Application no: H08/0023/09

Description: Repairs and renovations to dwelling

Location: 'Chespool House' Chesboule Lane
Gosberton Risegate

Amendment: Omitted 2 windows and removed internal temporary wall
(dwg. no. 1070-03)

Drawing Number
1070-03

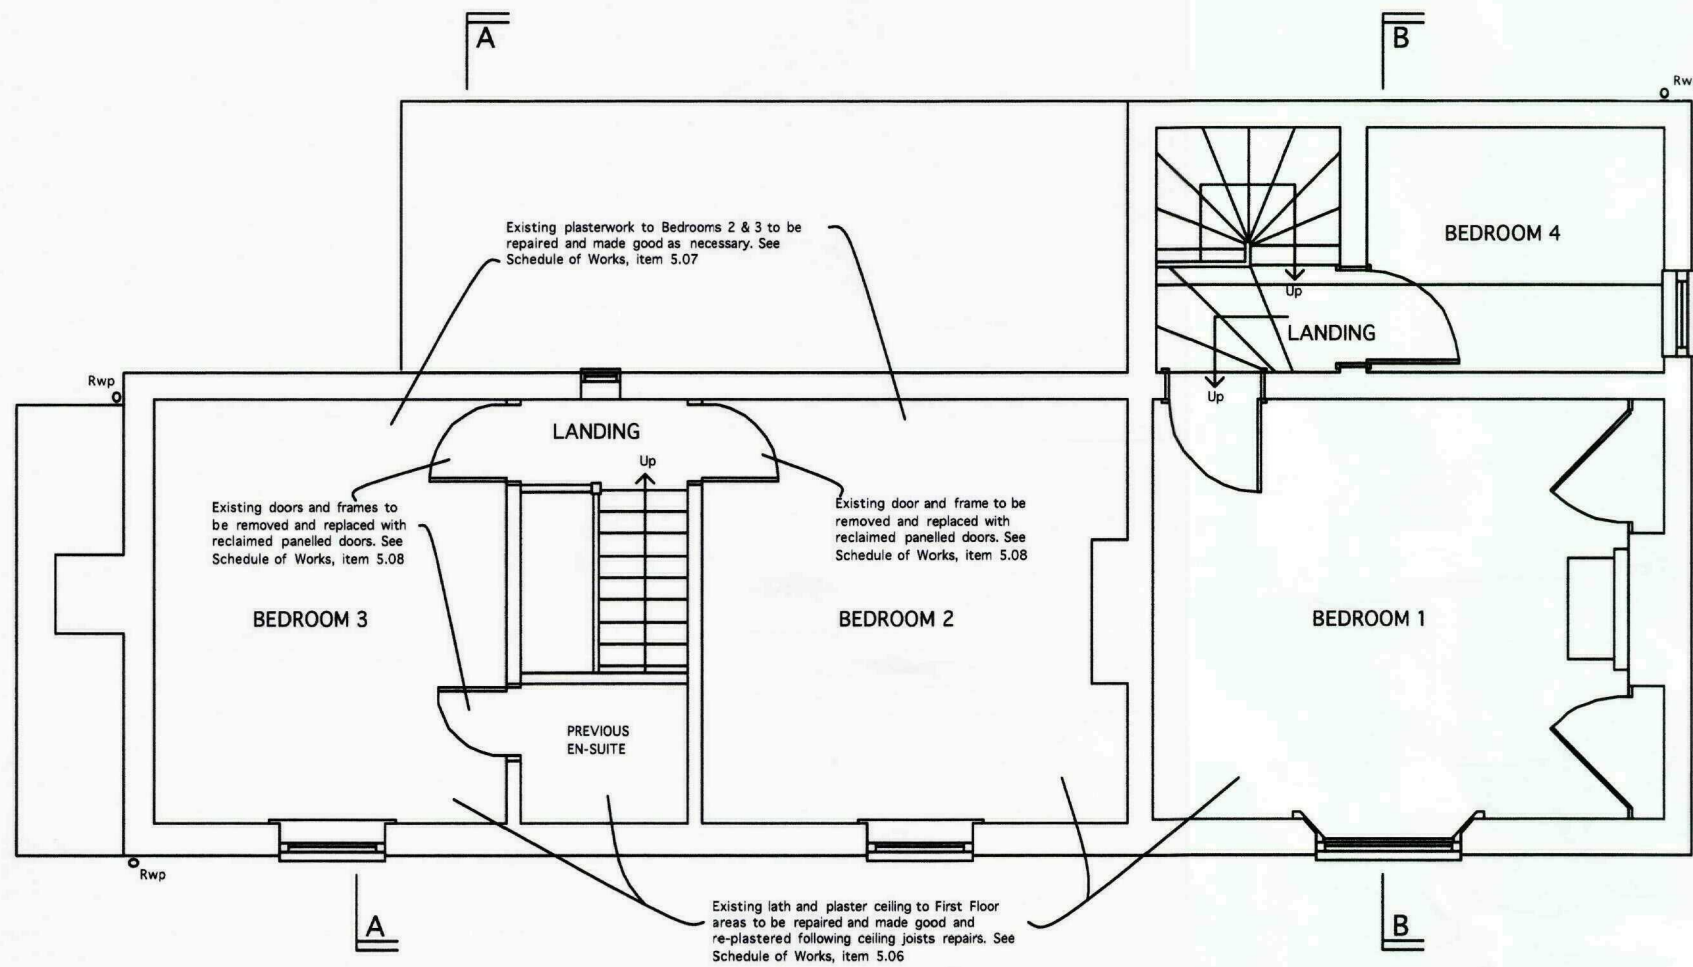
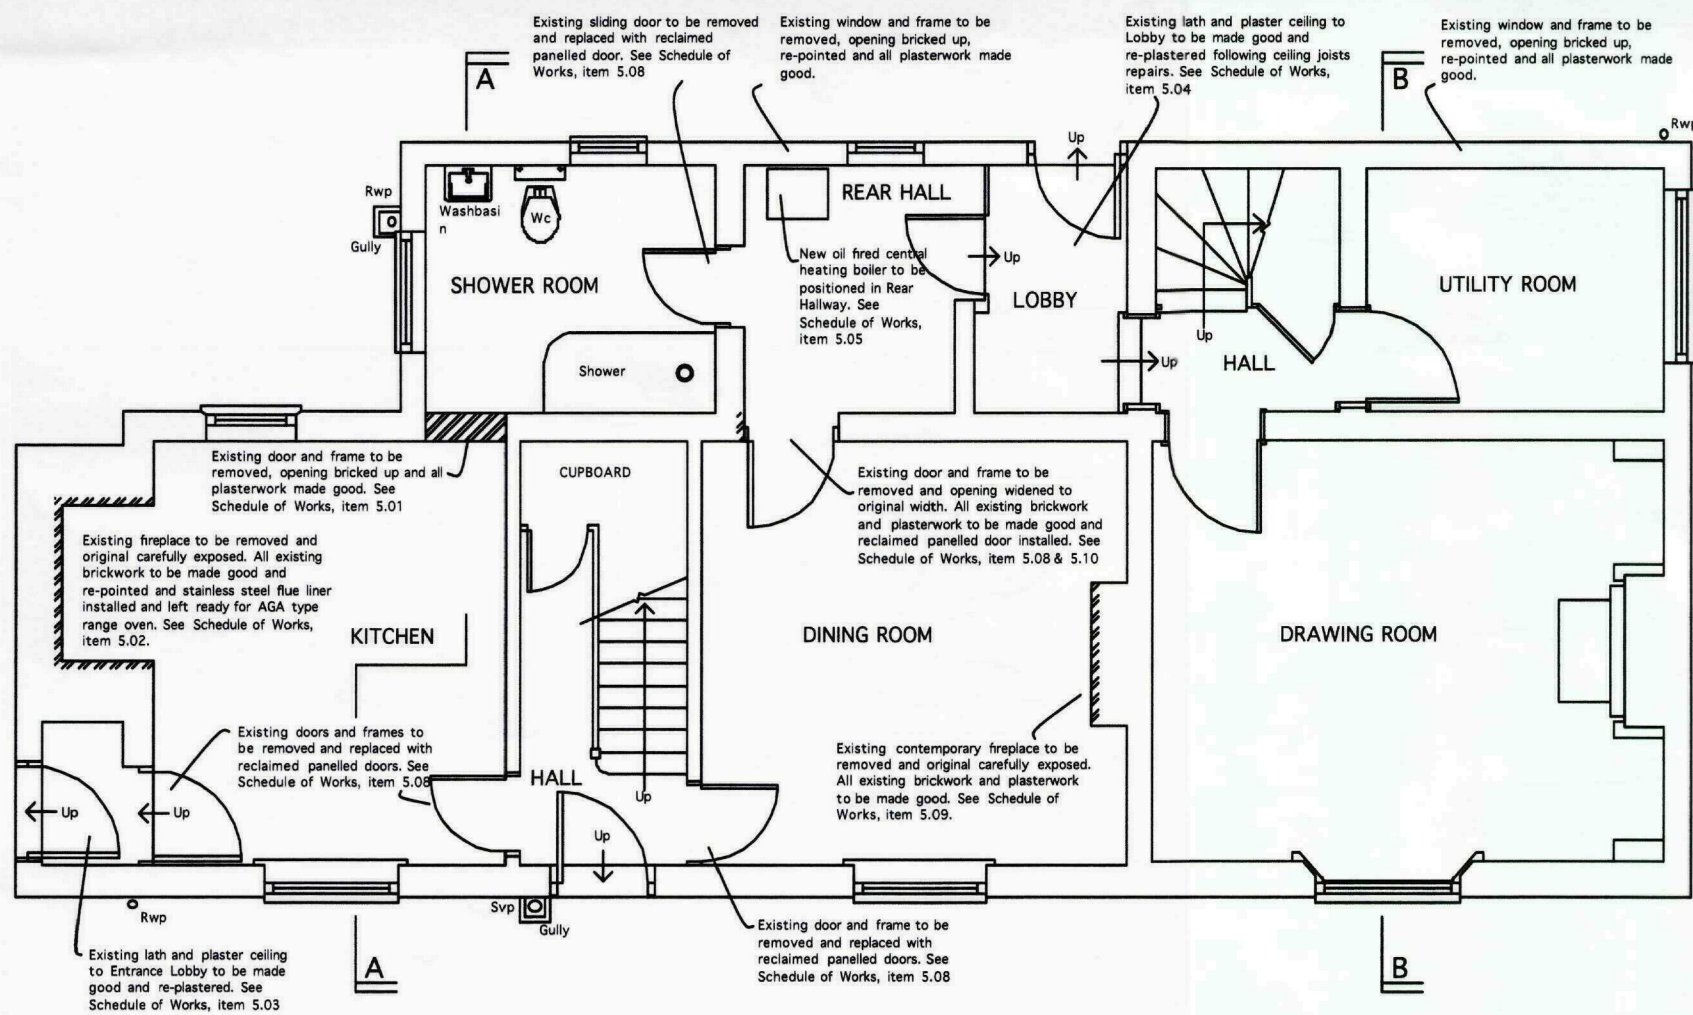
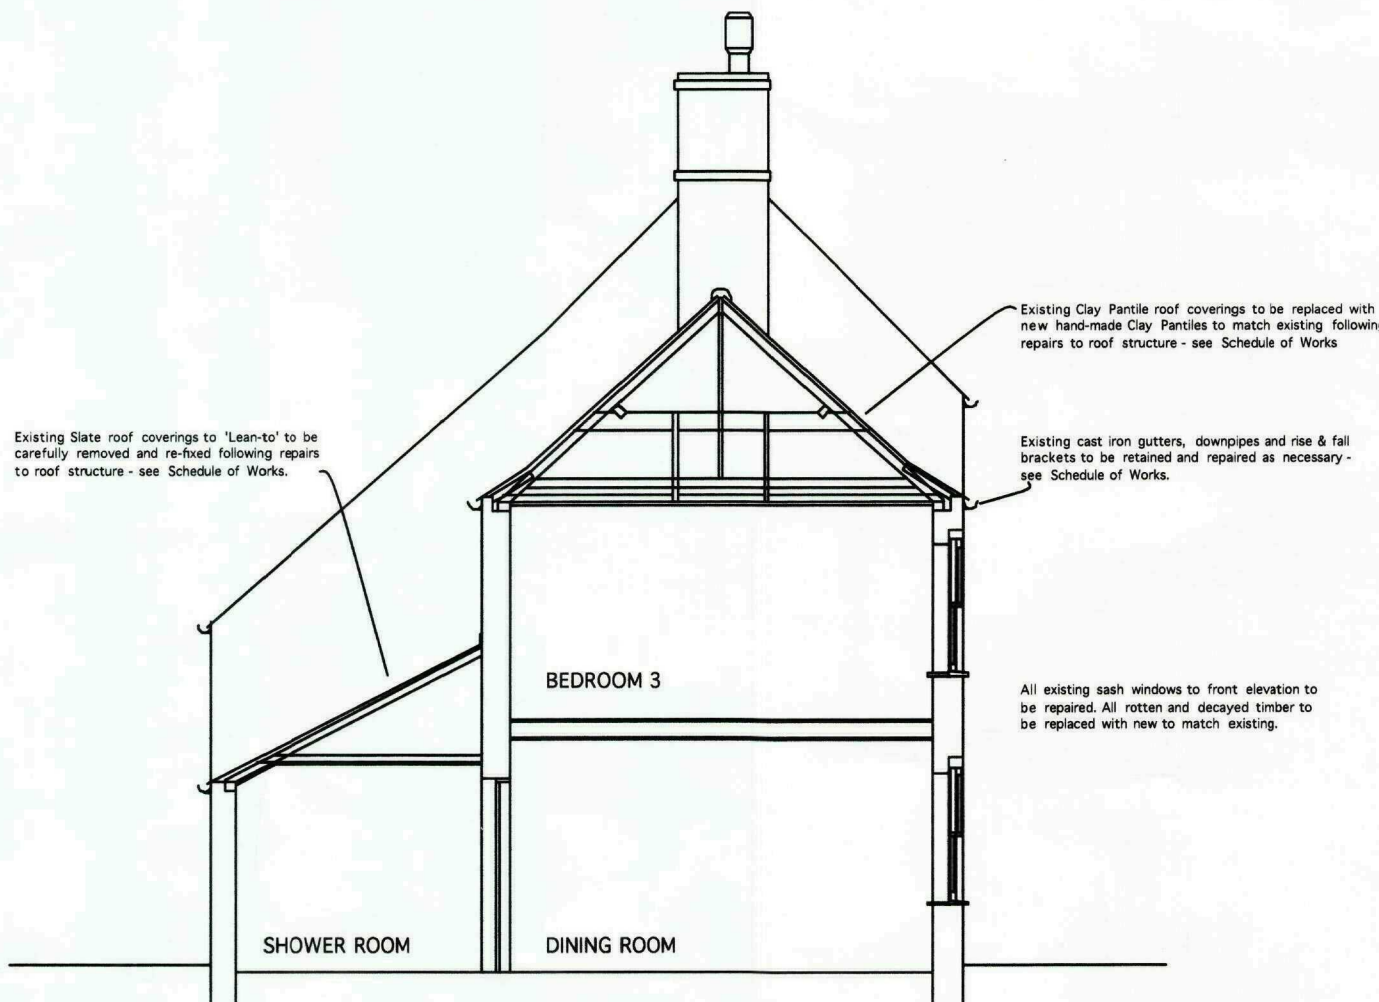
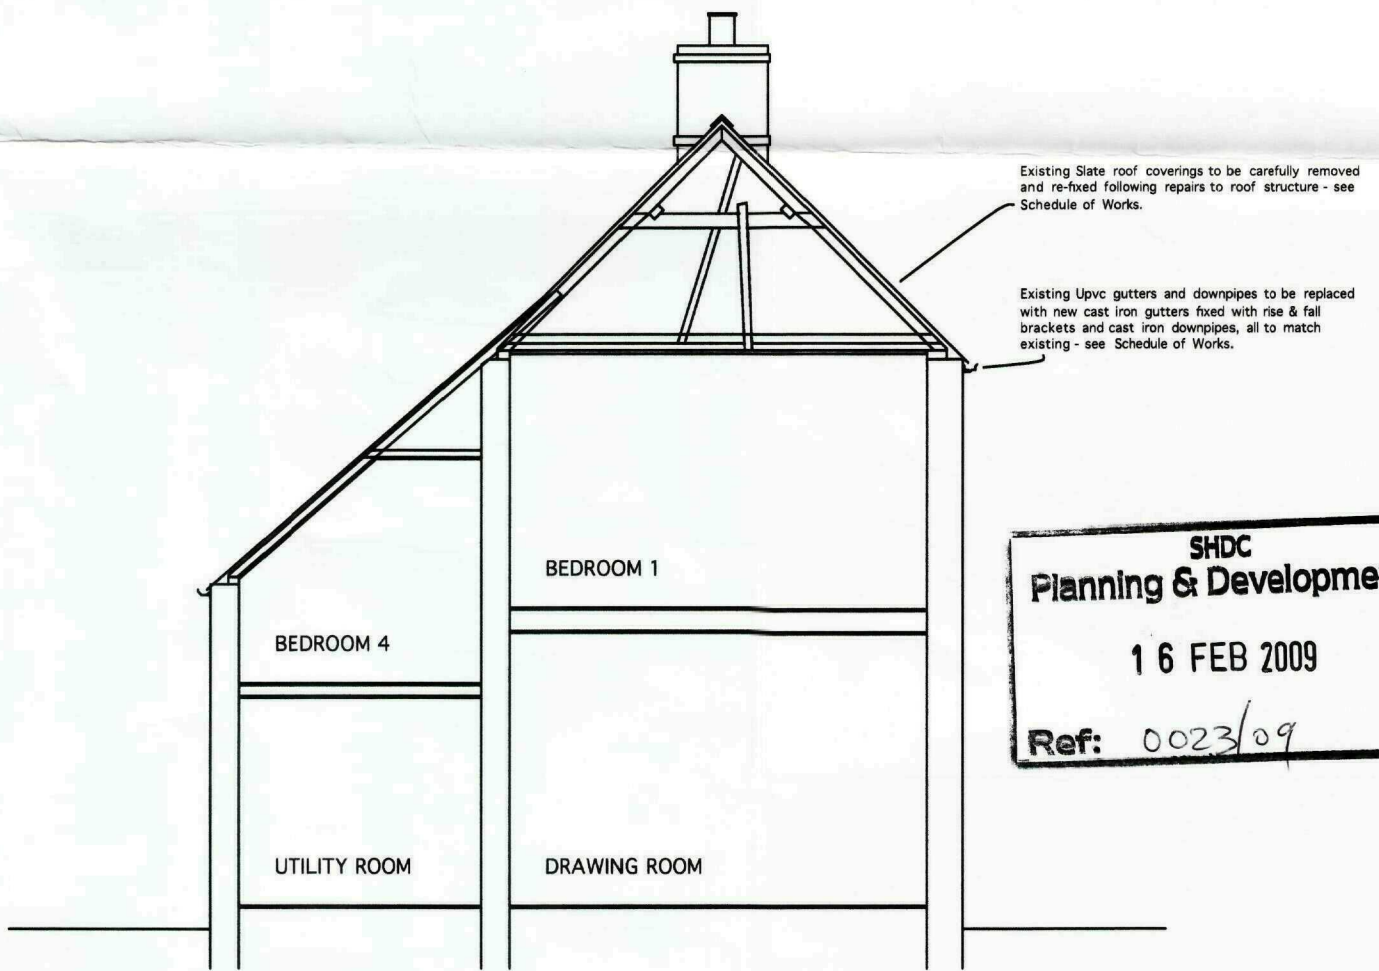
As discussed please find amended proposed elevations and floorplans for your records, I have removed from the drawing the two modern windows we discussed removing on site. I have also removed the temporary wall dividing the rear hall/lobby in two.
